Engineers Comments Regarding Surface Water Drainage

Application Reference:	A/43/26/PL	Reviewer Reference:	ADC/EXT2/D2134/103
Planning Officer:	Kathryn Welch	Date of Review:	18.05.2026
Site Name:	Broadlees Dappers Lane Angmering BN16 4EN		
Application Description:	Erection of 19 No dwellings. This application is in CIL Zone 2 and is CIL Liable as a new dwelling.		
Assessment Number:	1

DRAWN	DATE	CHECKED	DATE	APPROVED	DATE
SG	09.10.2025	MG	09.10.2025	MG	09.10.2025
CONTRACT NO:	23086				
PROJECT NO.	ORIGINATOR	ZONE	LEVEL	TYPE	DISCIPLINE NUMBER
23086	ARC	XX	XX	DR	D - 5010 - P4

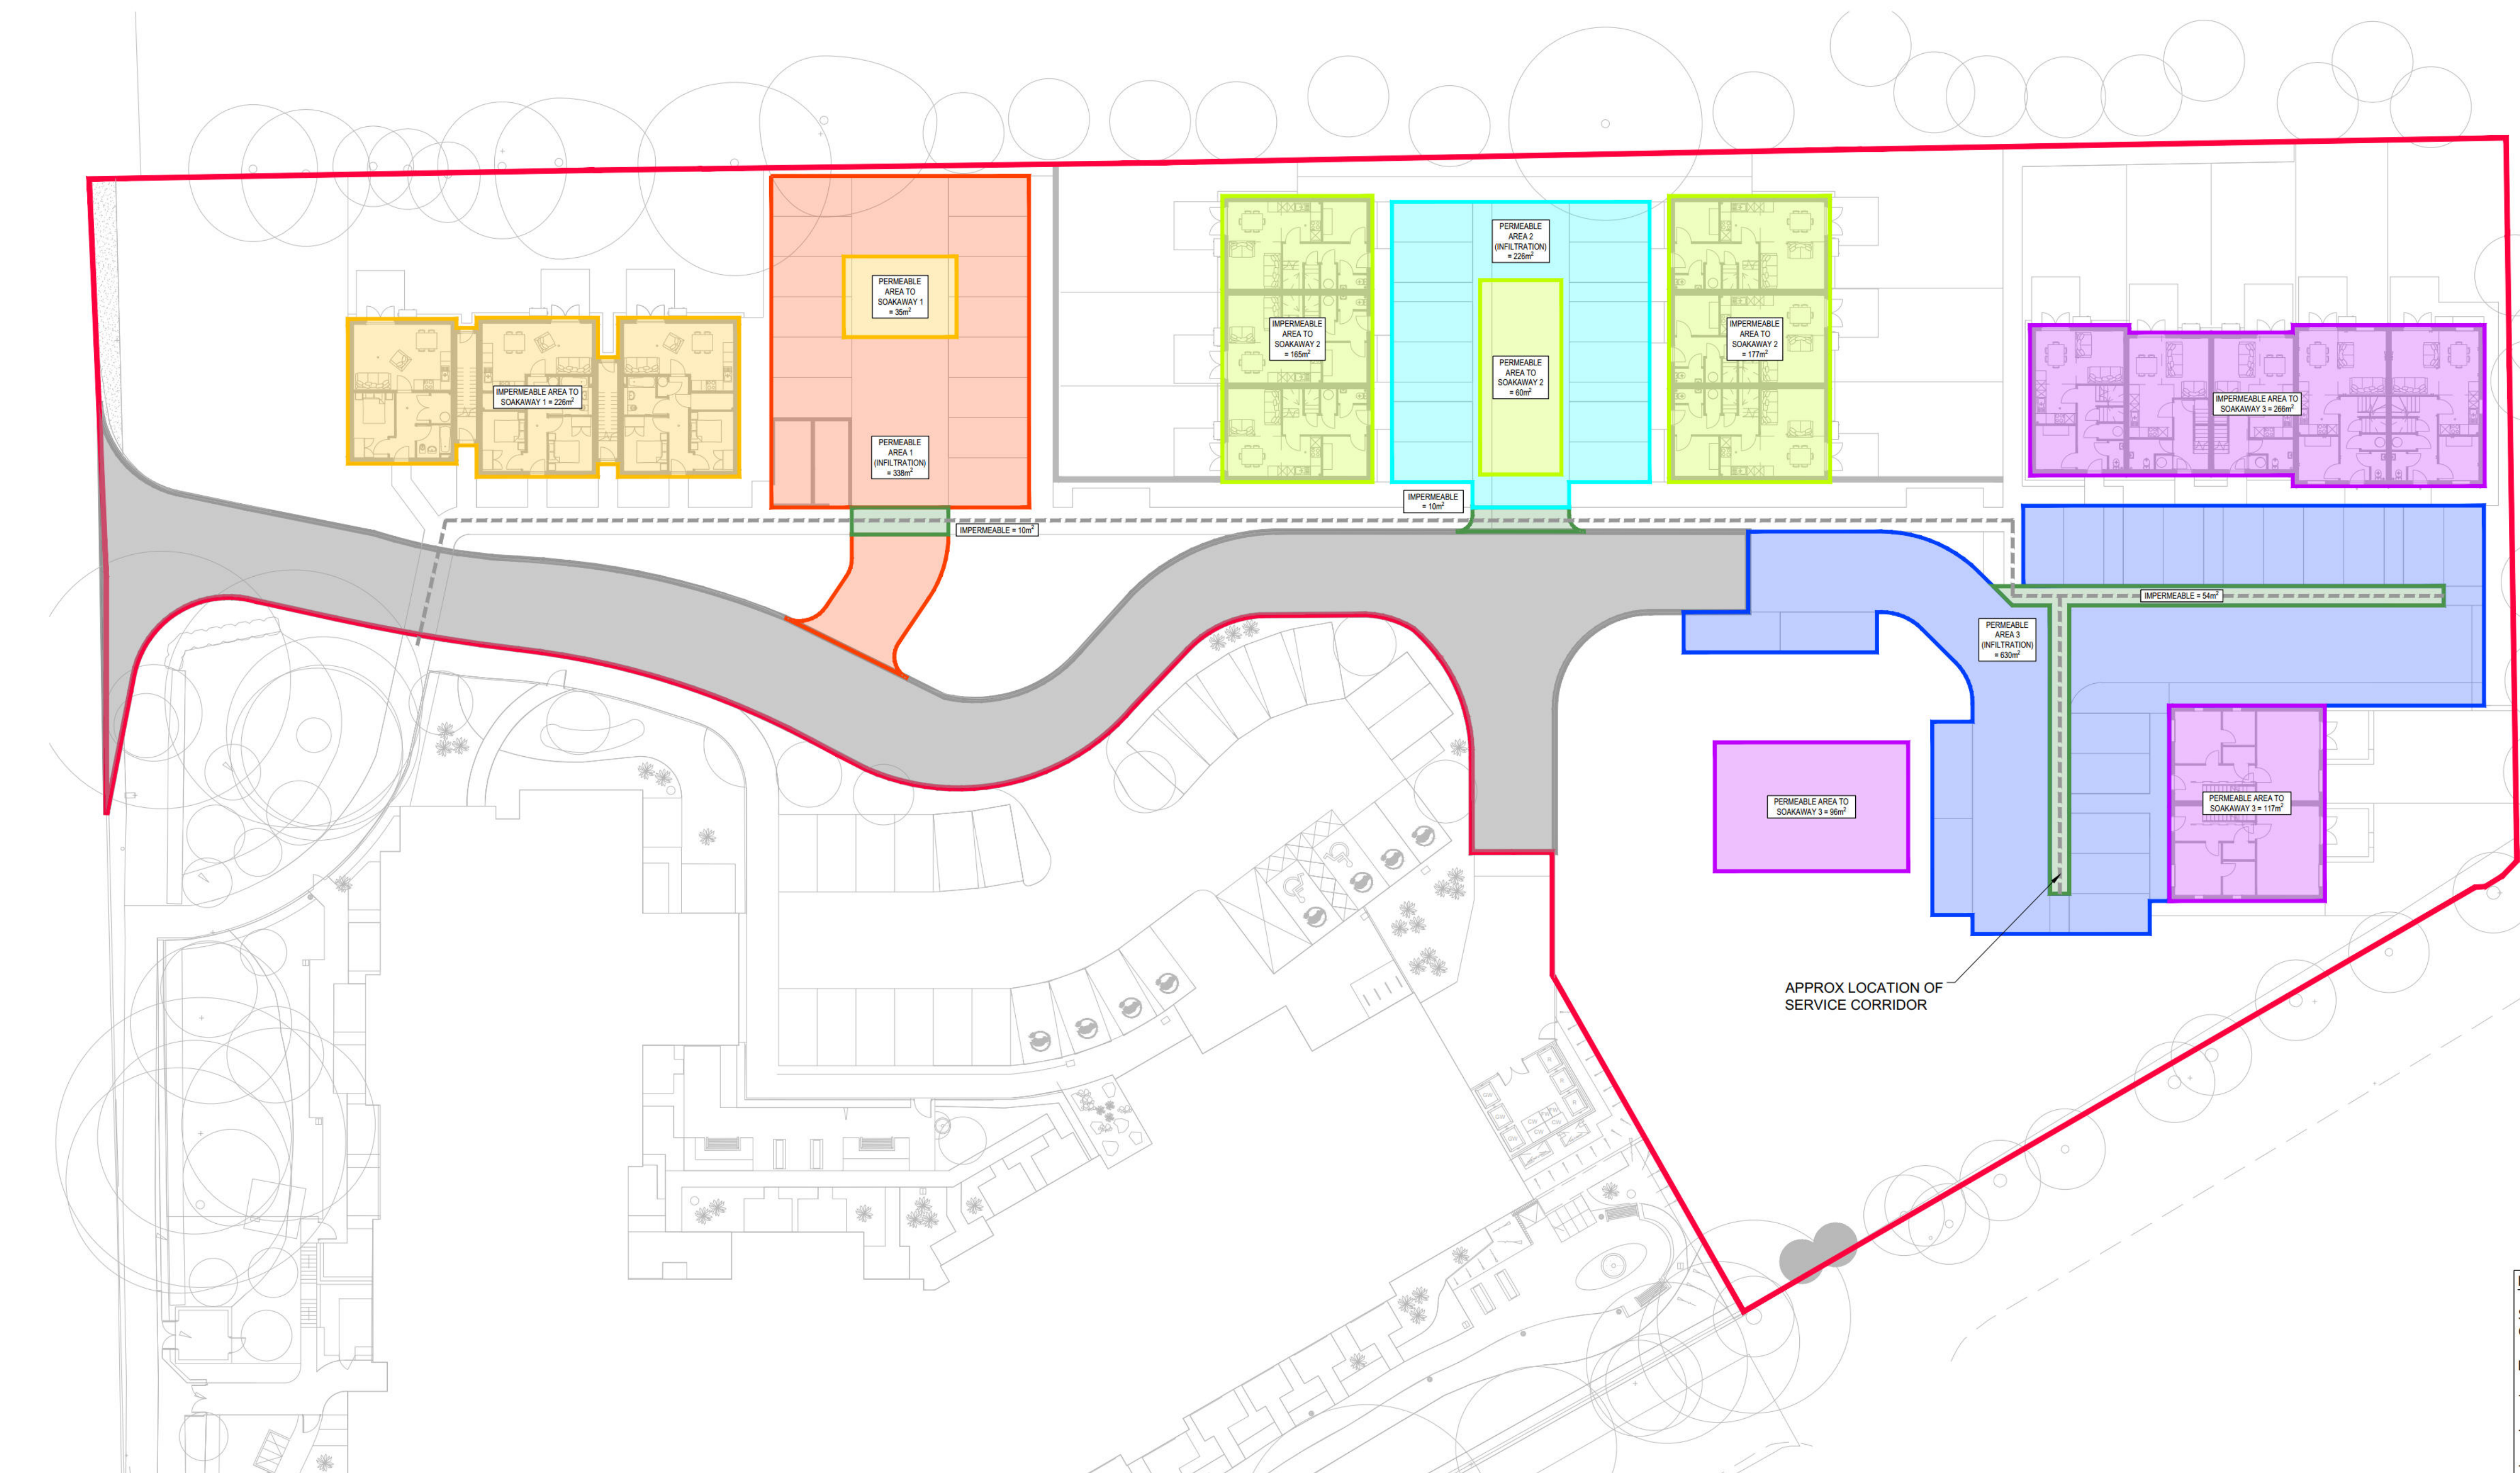
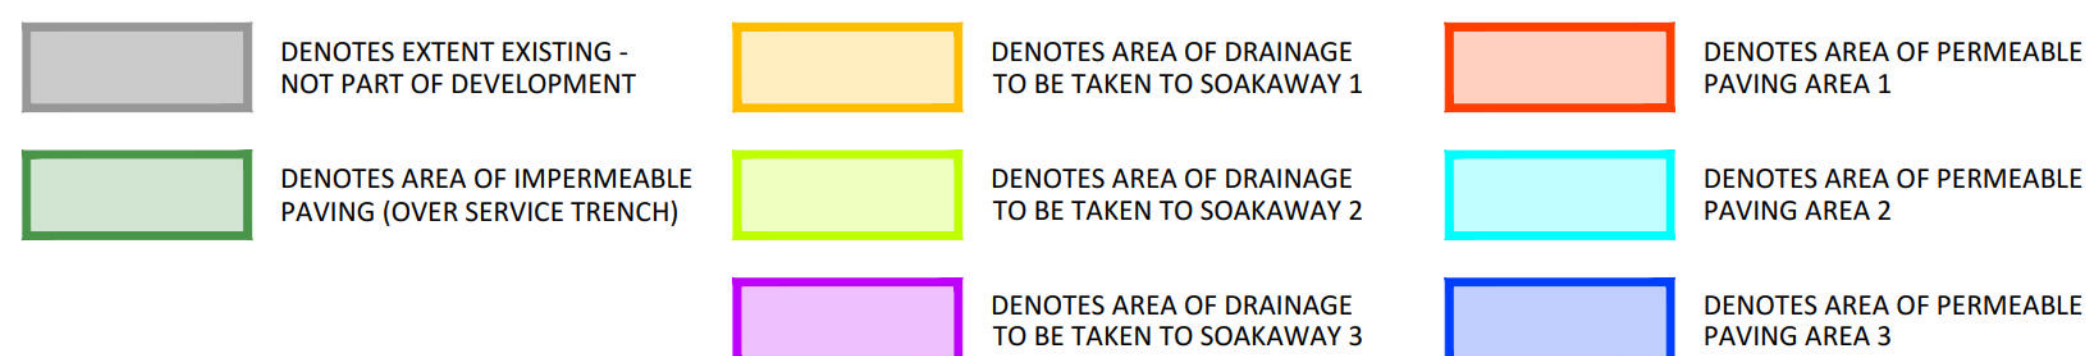
- 3.2. All calculations must also demonstrate the 50% half drain down time lies within 24hrs for the 30yr event.
- 3.3. Drawing 5010 must highlight the overall/total impermeable area including the permeable paved areas.

CORRIDOR SERVICE DETAIL 1
SCALE 1:20

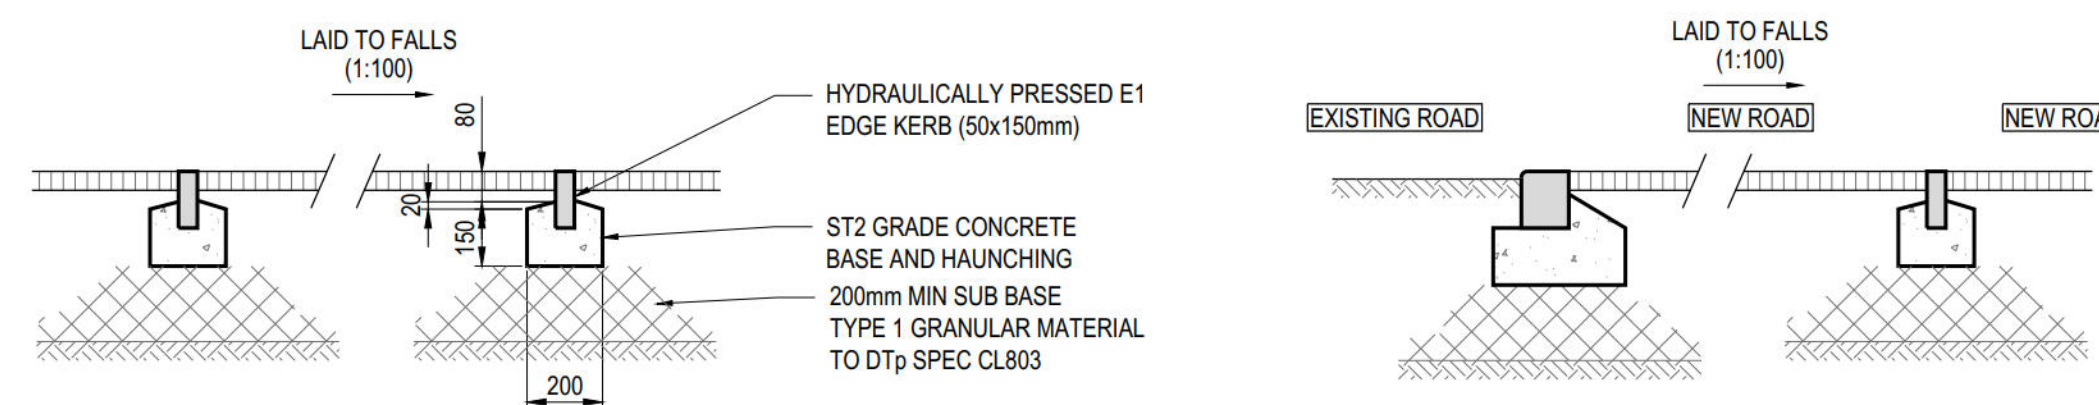
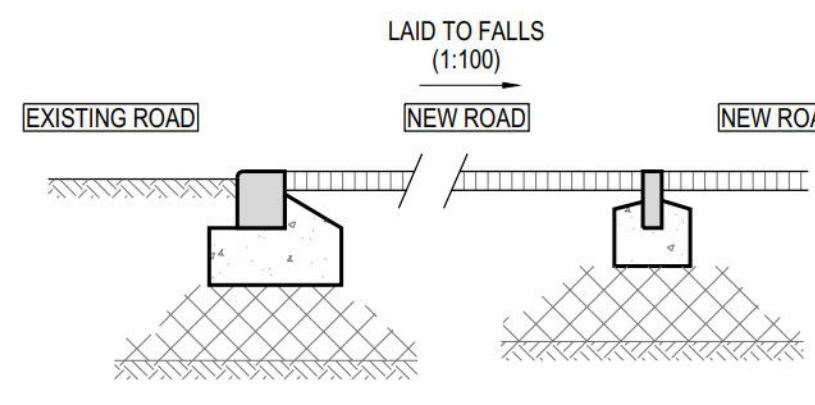
- 3.4. How are mains services affected by the permeable pavements? It is expected that service corridors will impact the permeable pavement resulting in traditional strips thus reducing the areas shown. The same may also apply to the routing of the foul drain.
